From: Iain Osenton
Sent: 23 September 2019 10:35
To: Planning
Cc: Caroline Ford
Subject: 15/00138/DISC - CDC Arboriculture

DRAWING TITLE:
**NORTH FRONTAGE
SOFT LANDSCAPE PLAN
FINAL SCHEME**

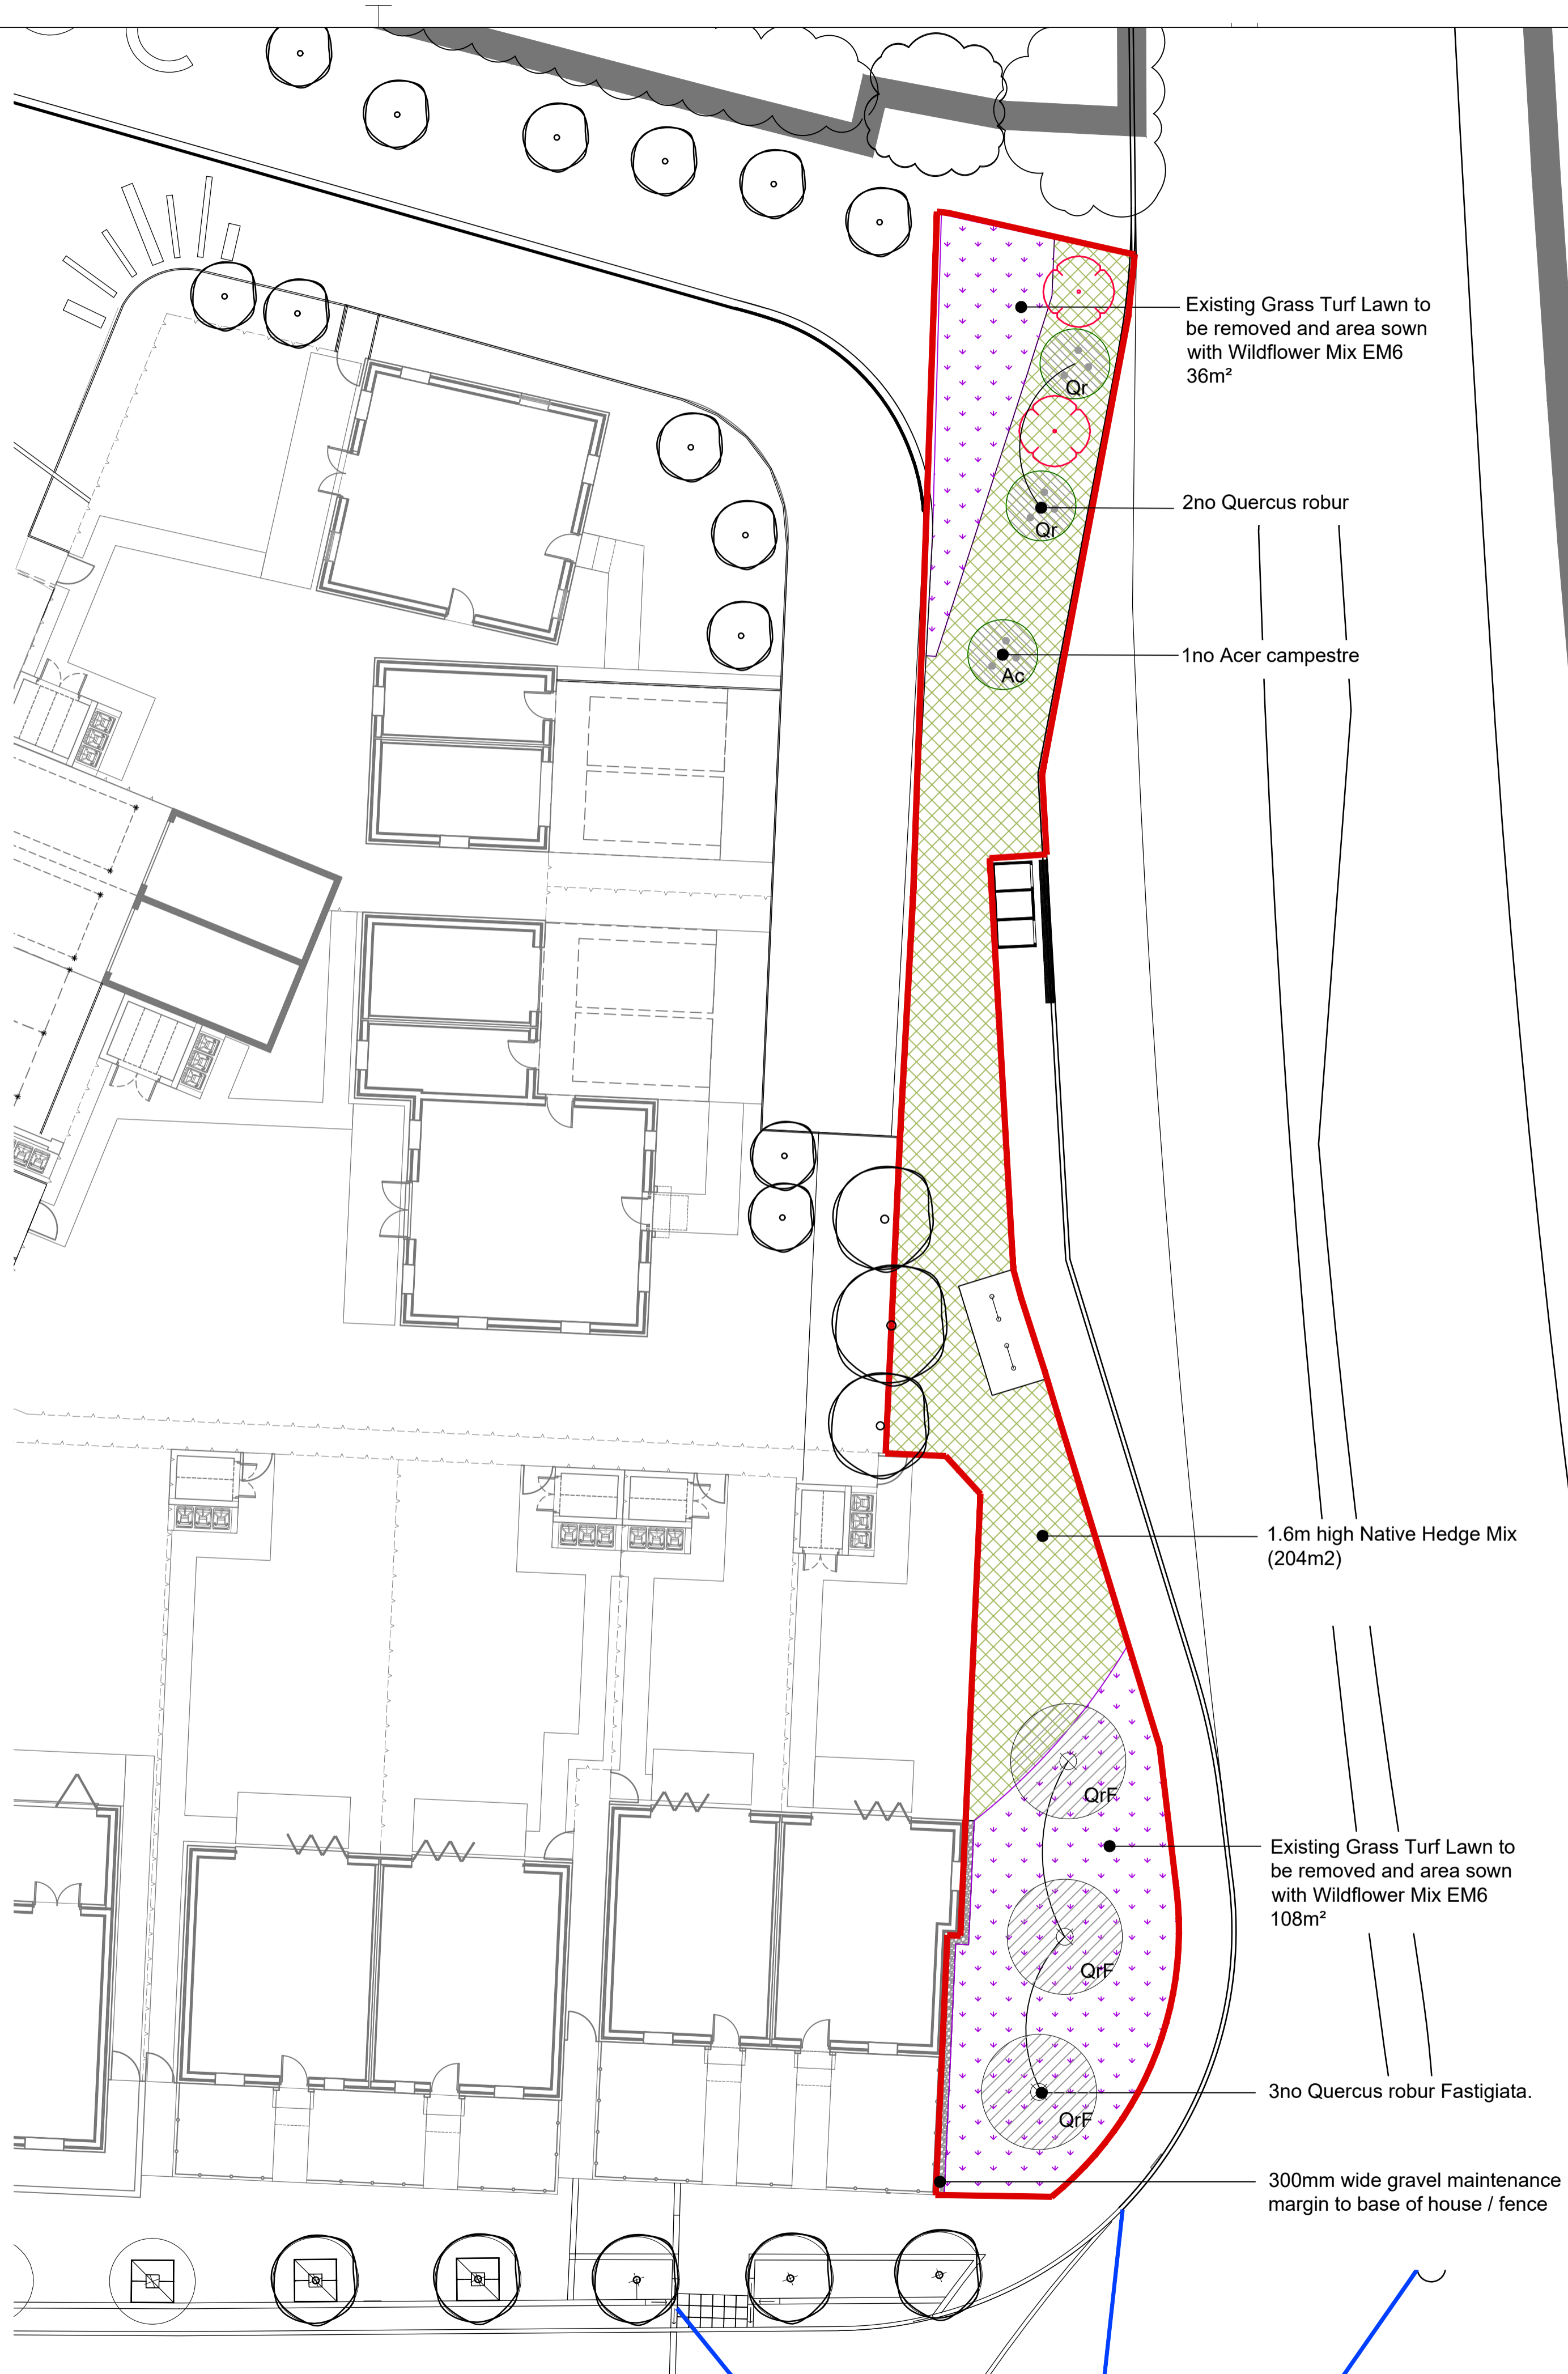
Also I have concerns for the 3 Quercus Robur Fastigiatas due to their proximity to both a building, and a junction. Could I suggest this be amended to 2 trees in order to reduce water uptake potential, and future shading to the house?

DRAWING TITLE:  
**SOUTH FRONTAGE  
SOFT LANDSCAPE PLAN  
FINAL SCHEME**

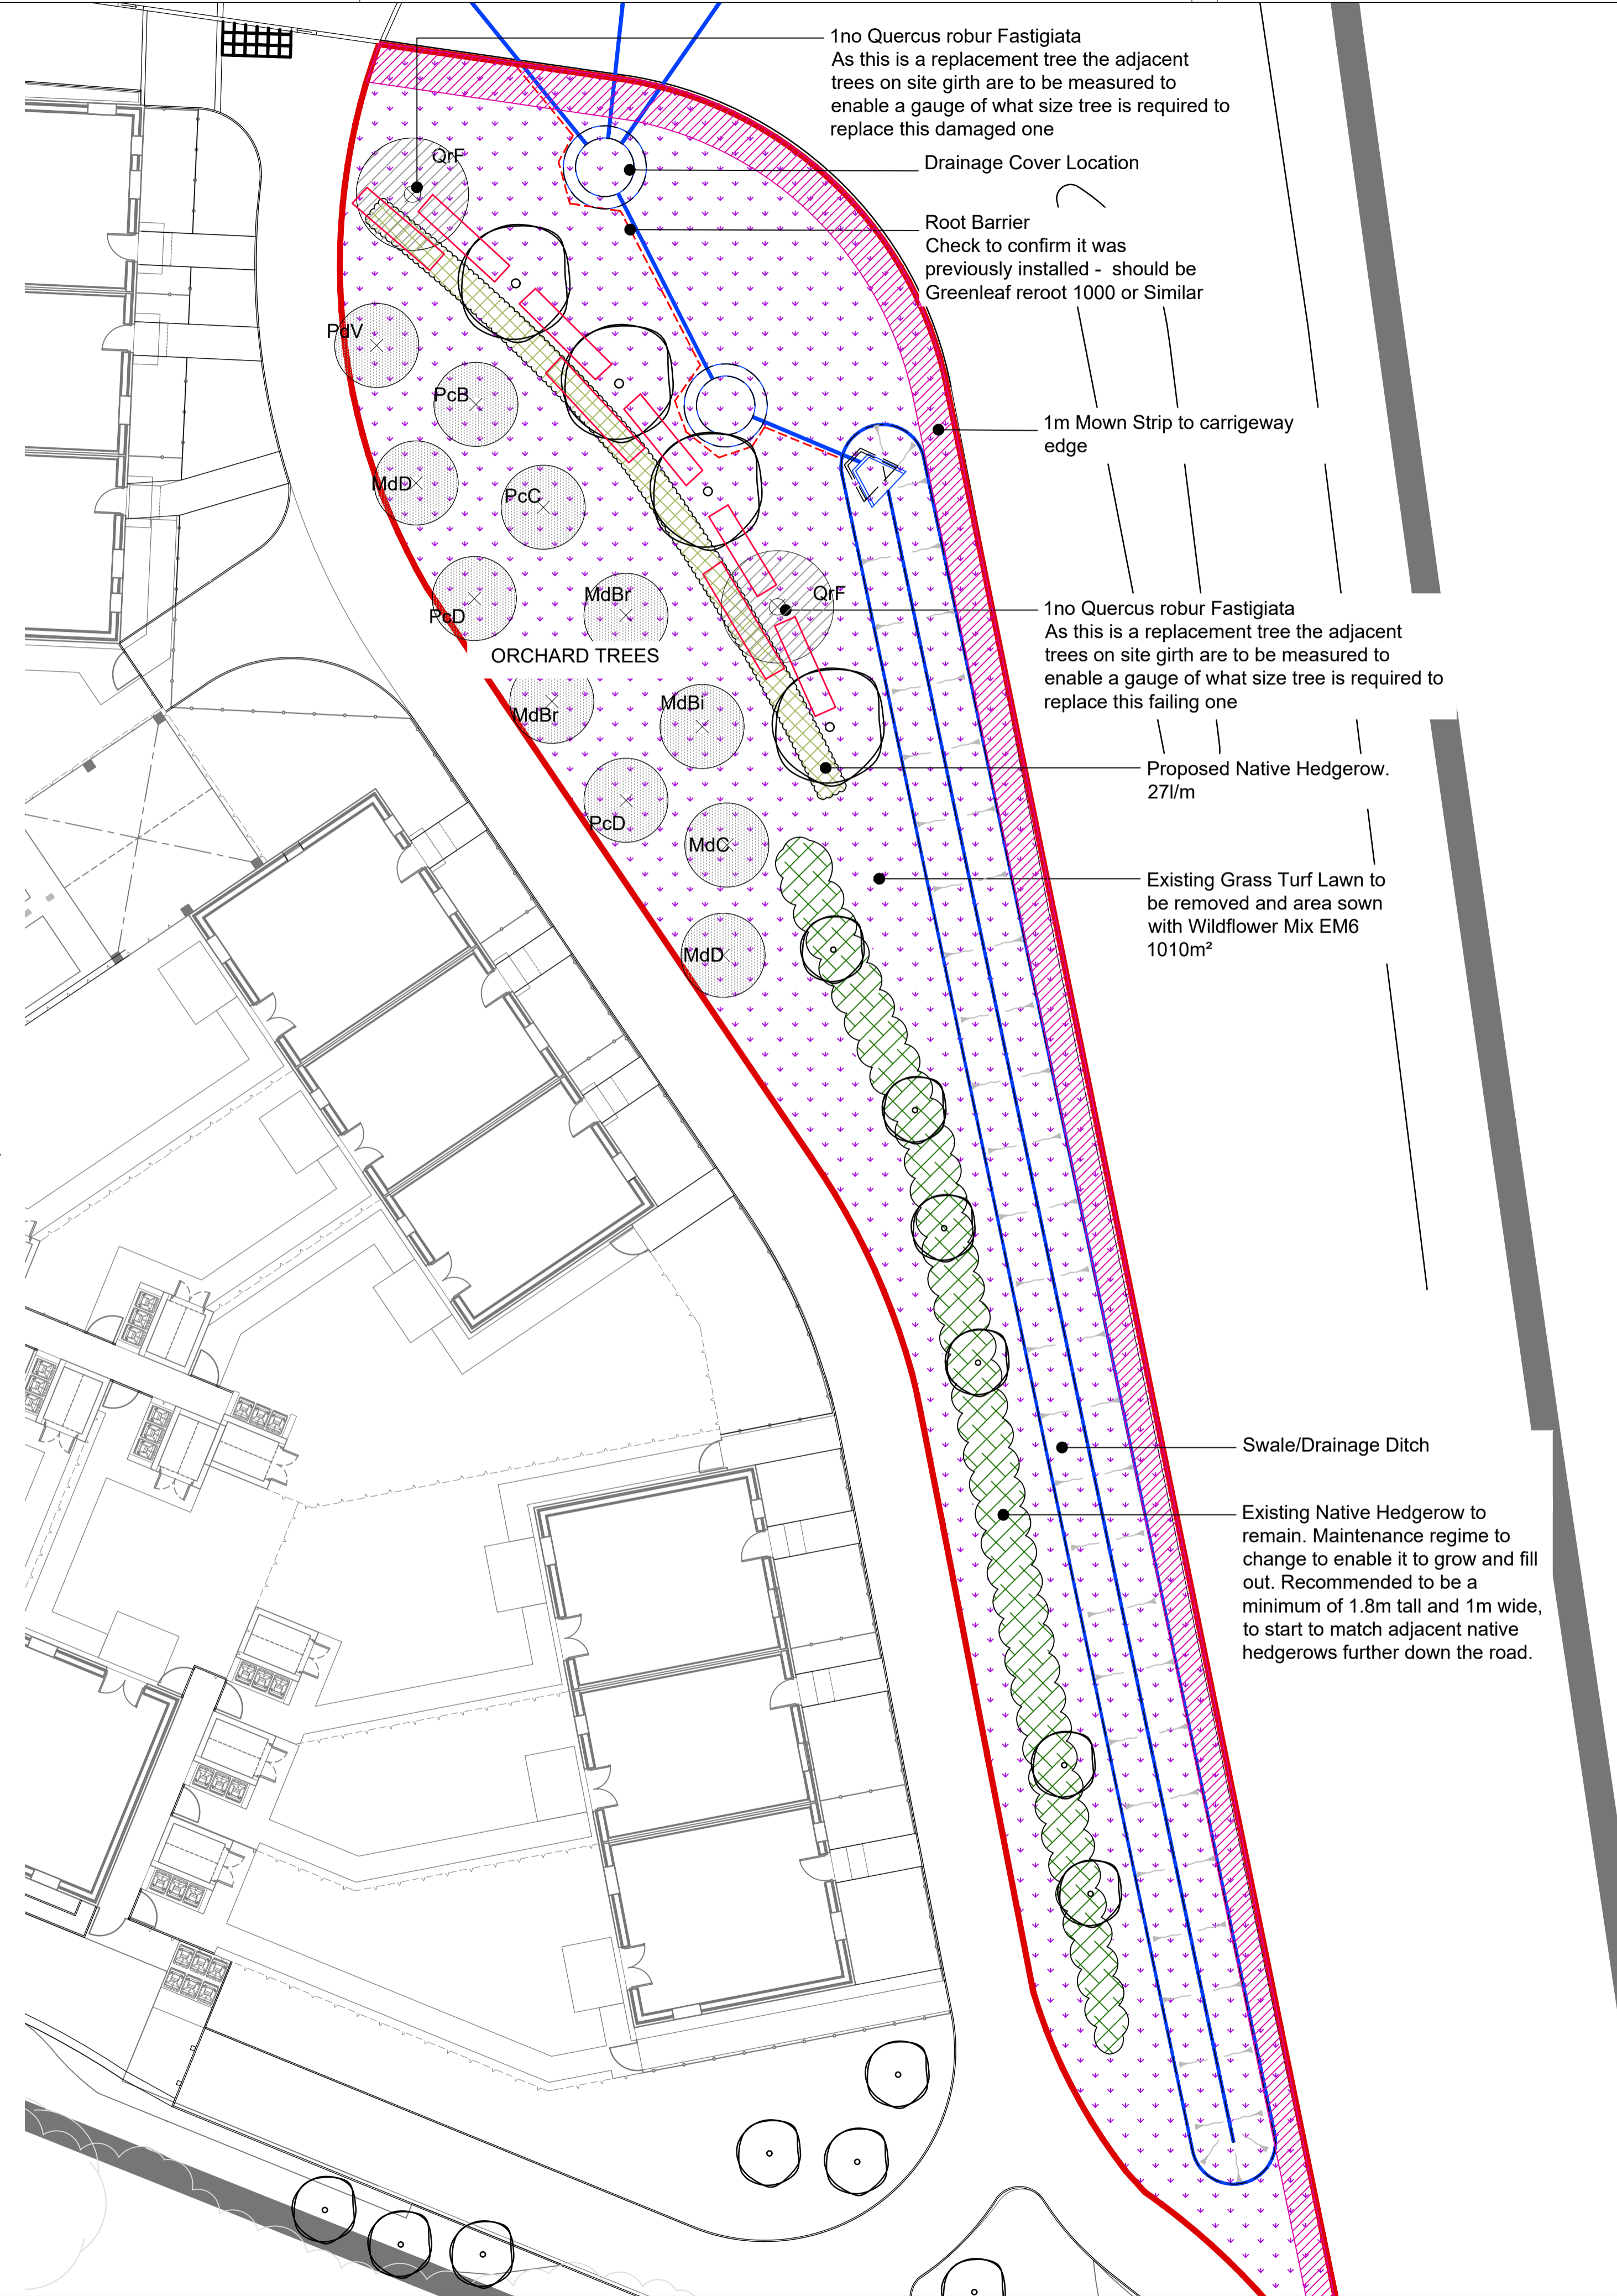
Regarding the above Disc, I hold concerns for the "Orchard trees" where some appear to overhang into the road. This will likely bring future maintenance pressures due to falling fruit. Could this be amended to create a gap between the road edge, and the 1st canopy spread?
